KITTITAS COUNTY

TO: All Staff
FROM: Public Works Plan Review Team
DATE: April 4, 2025
SUBJECT: LPF-25-00002 Sasse

RE: 202501237; LPF-25-00002, LP-11-00002

SASSE RIDGE PLAT

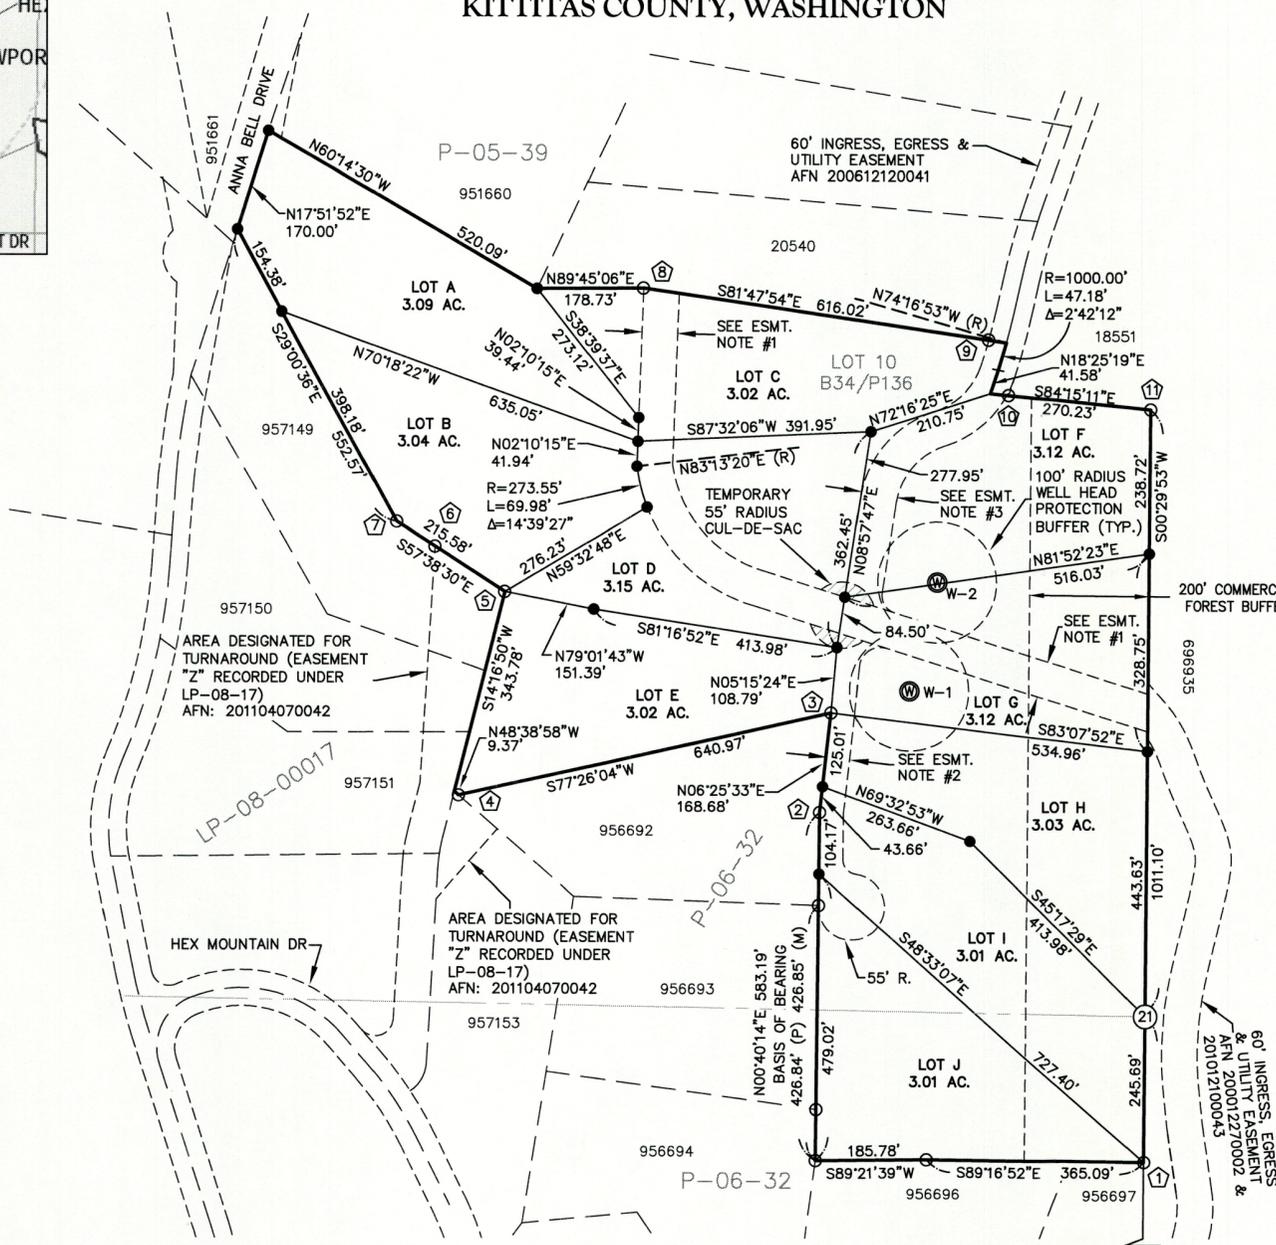
hundred (500) cubic yards shall be accompanied by an engineered grading plan (KCC 14.05.080). (CC)
SURVEY	<ol style="list-style-type: none">1. Easements S, T and U shall be denoted as to if they are existing, herein created, or created via separate document. If they are existing, include reference to the document recording number. If they are herein dedicated, they need to be retraceable, either by including metes and bounds, or including language “centered about existing road” (or similar).2. The areas denoted as “Temporary 55’ Radius Cul De Sac” needs to address whether it is existing, herein dedicated, or to be created via separate document. If existing, include reference to the recording number, if herein dedicated, it needs sufficient data for mathematical retracement. Please address the temporary nature, via a note detailing what action would terminate the easement.3. Please label roads with R/W width, ownership and surfacing (EX: Anna Bell Drive-60’ Private R/W-Paved)
